Please see responses to City of Mercer Island intake screening comments below as relevant to civil plans:

CIVIL INTAKE COMMENTS

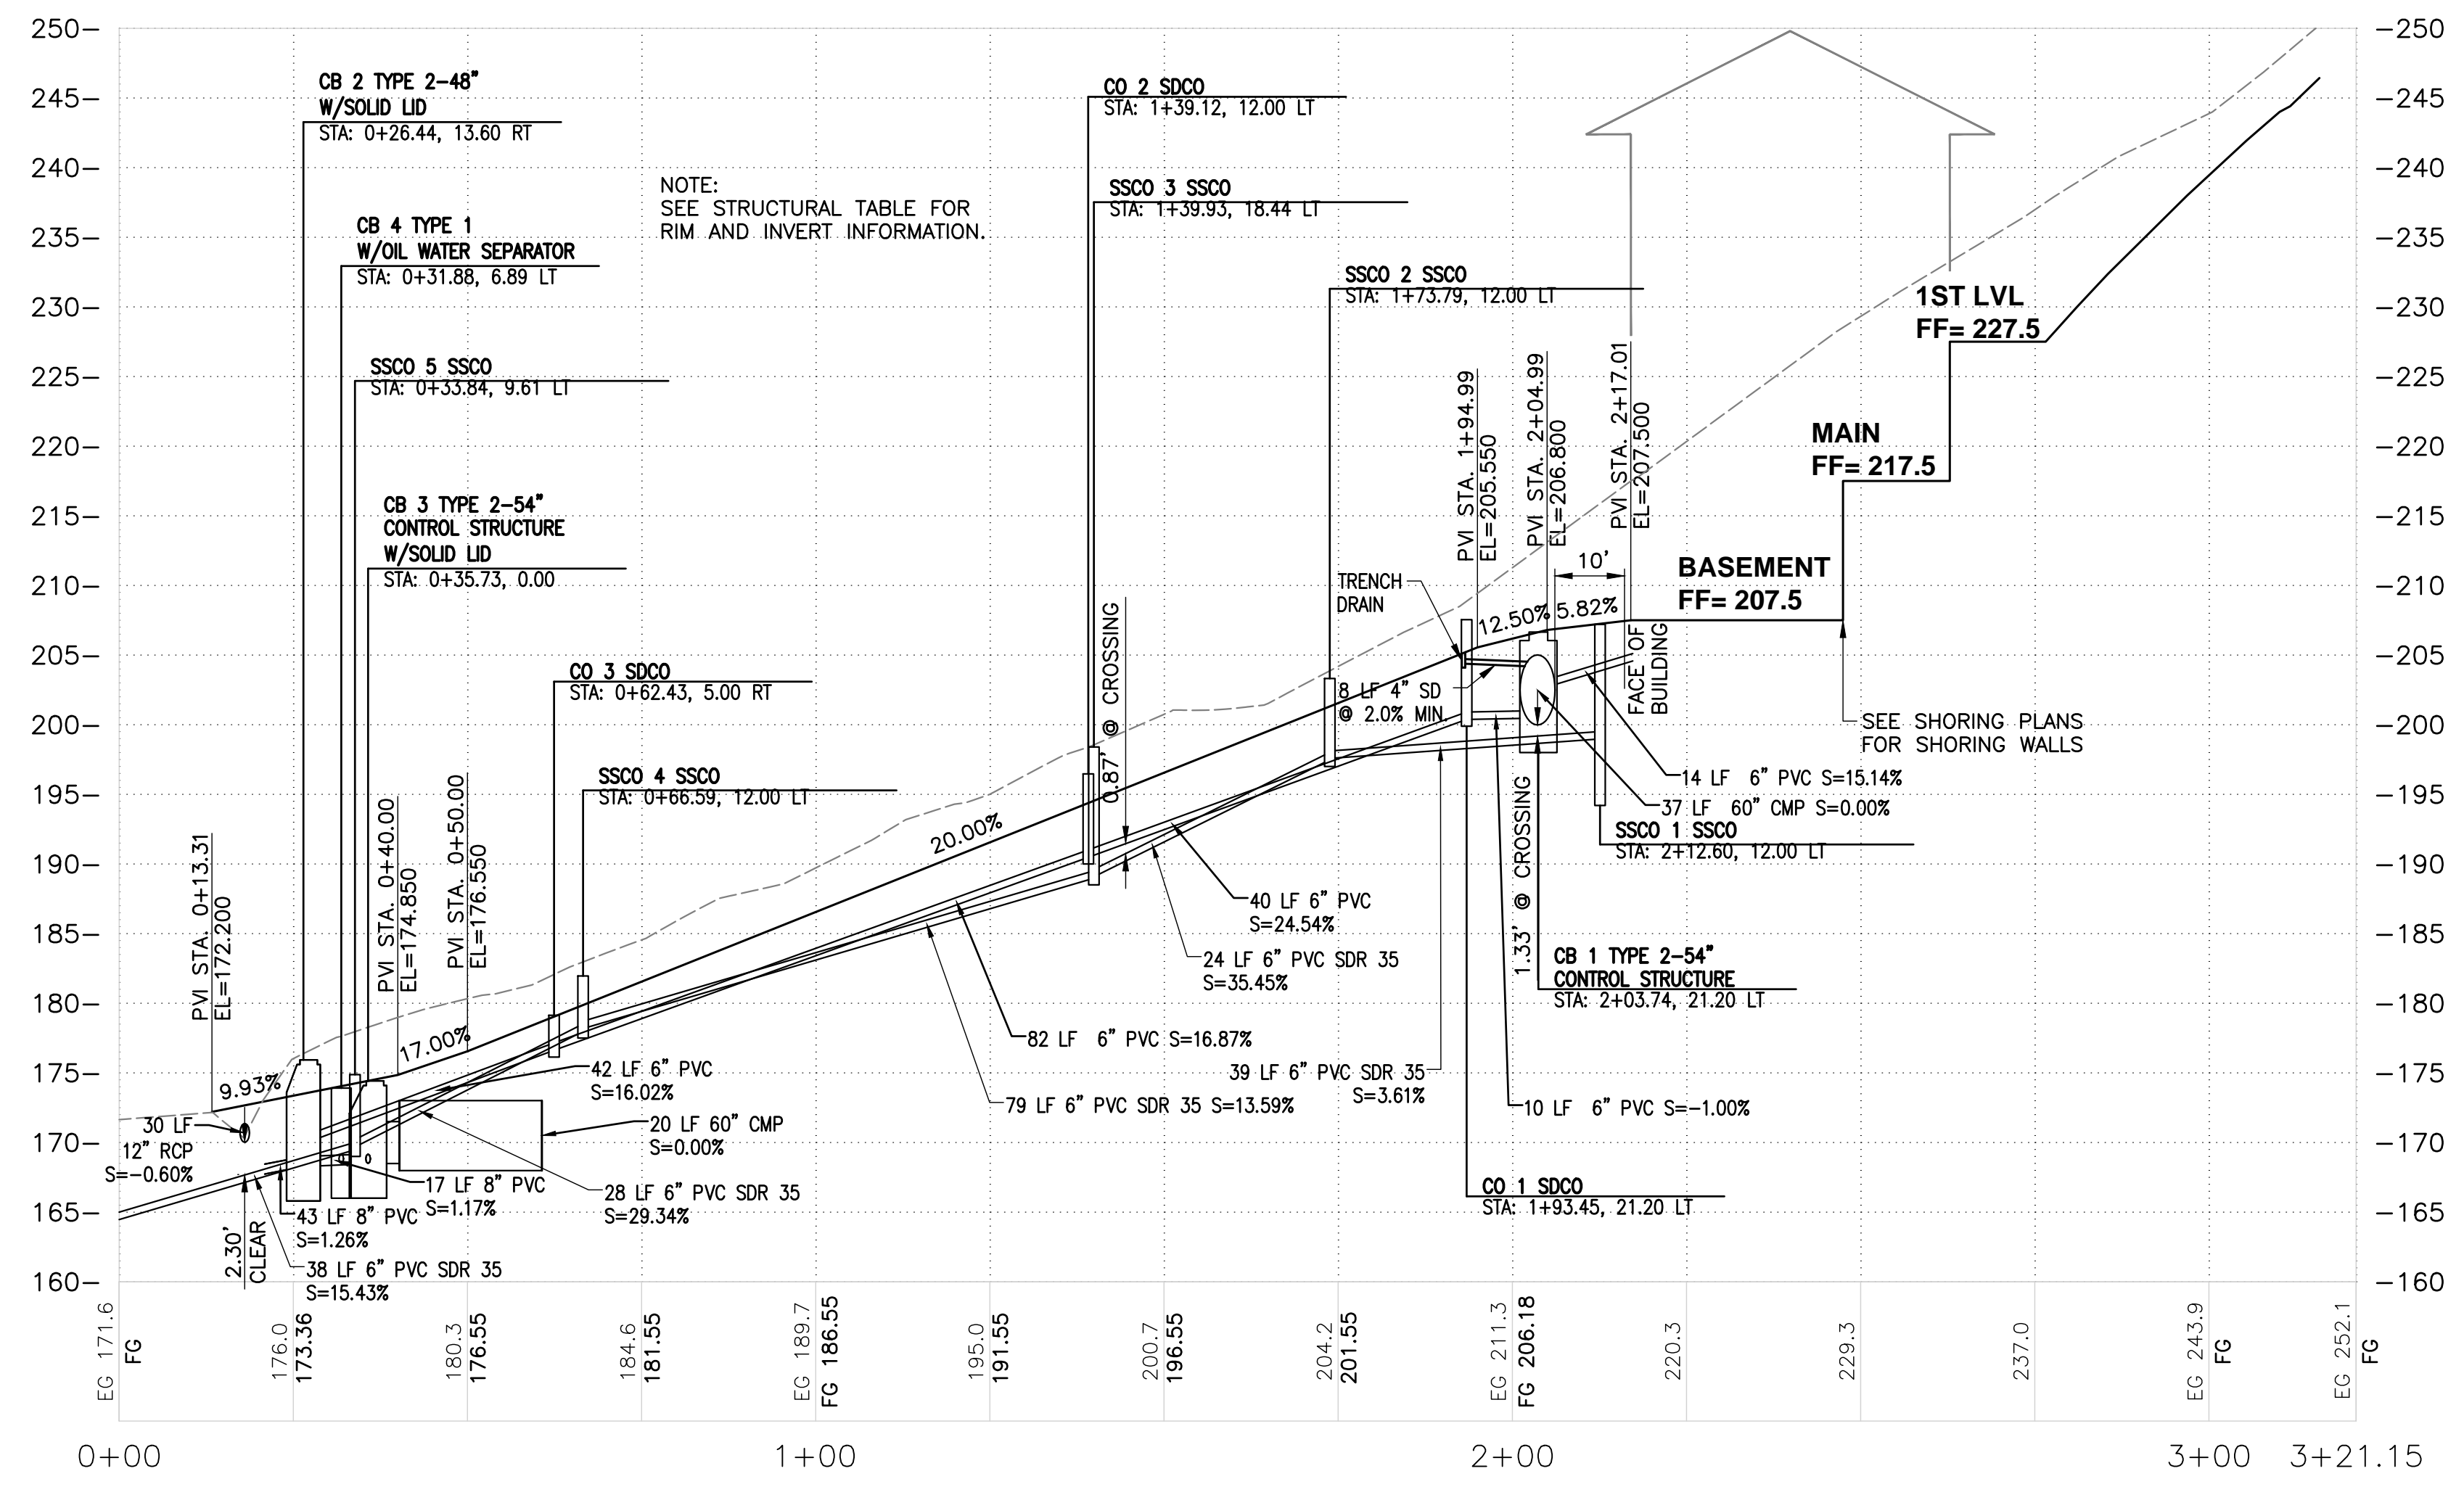
Comment: The side sewer is shared and requires a backflow prevention valve

Response: Side sewer backflow prevention valve has been added to design. See civil plans sheet C2.0
